# COUNTY COUNCIL'S RESPONSE TO CONSULTATION ON THE FOLLOWING DEVELOPMENT PROPOSAL

**Application No:** 19/02948/F

**Proposal:** Erection of 10 No two storey residential dwellings with access off South Side including a new pedestrian footway, parking and garaging, landscaping and all enabling and ancillary works

**Location:** Land To The South And Adj To South Side Steeple Aston

Plan showing proposed pedestrian infrastructure along South Side

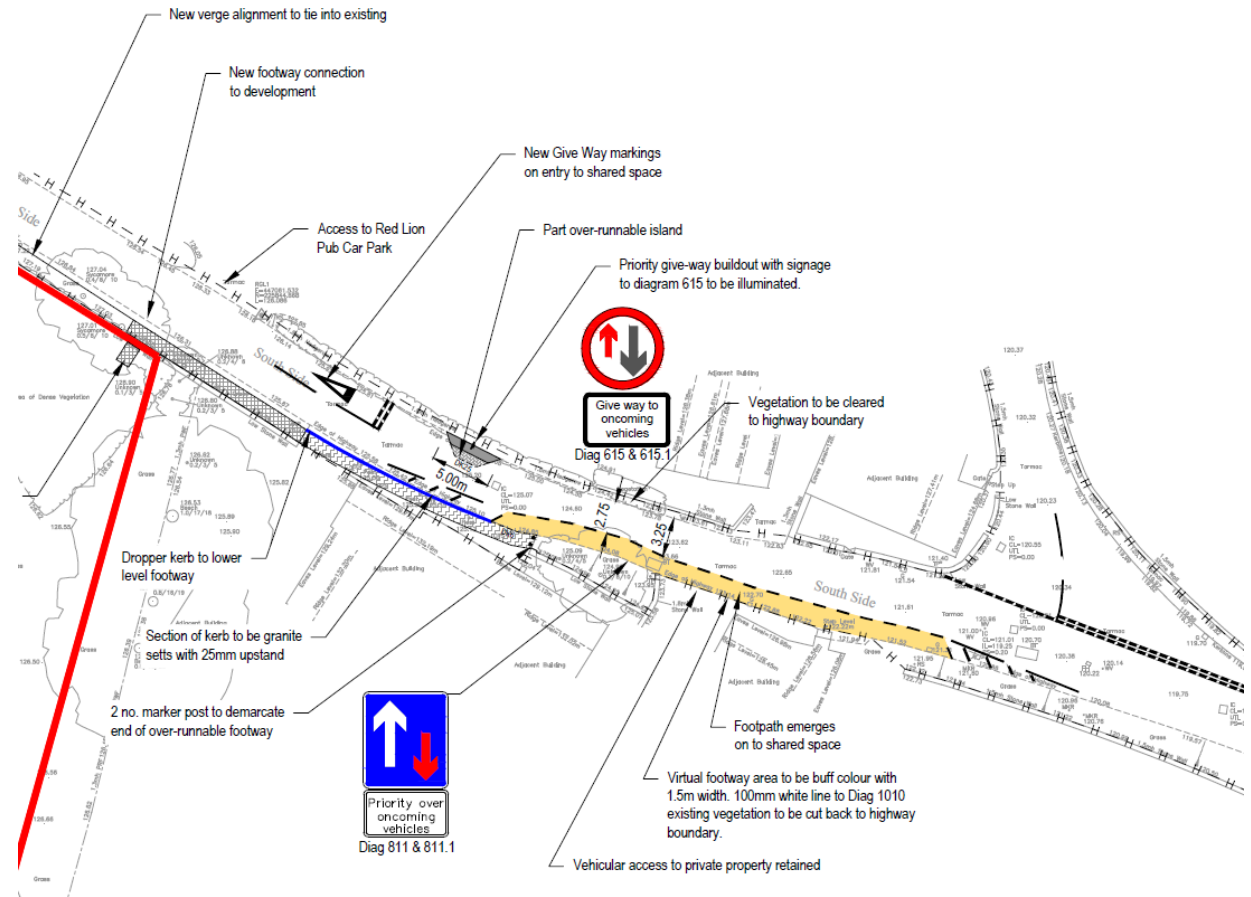
Drawing number 8171225/6110 has been revised up to A2 with the inclusion of the three points mentioned above. The improvements will provide facilities for pedestrians where they currently share the highway with vehicles, along the southern edge of South Side between the site and Water Lane. The facilities consist of a short length of kerbed footway at the western end, a section of over-runnable footway across the residential access and frontage, and a coloured virtual footway. This revision of the design was subjected to a full Stage 1 Road Safety Audit.

- Problem 1. The response is agreed.
- Problem 2. With the build-out reduced in size (i.e. half over-runnable) it may be difficult to position the signs with sufficient set-back from the carriageway. It is worth considering having flexible marker posts (e.g. TMP or similar) on the build-out, with the sign assembly relocated to the west, possibly to the car park access where it is less susceptible to being obscured by vegetation. If there is adequate space for the sign assembly on the build-out then the "Priority over oncoming vehicles" sign could be placed on the reverse.

- Problems 3, 4, 5 and 6. The responses are agreed.
- Problem 7. OCC strongly favour having the same arrangement of demarcation as that used nearby on the virtual footway at Stonesfield. This uses two red reflectors back-to-back in white plastic housings (so they show up well in daylight too), placed just outside a continuous white line.
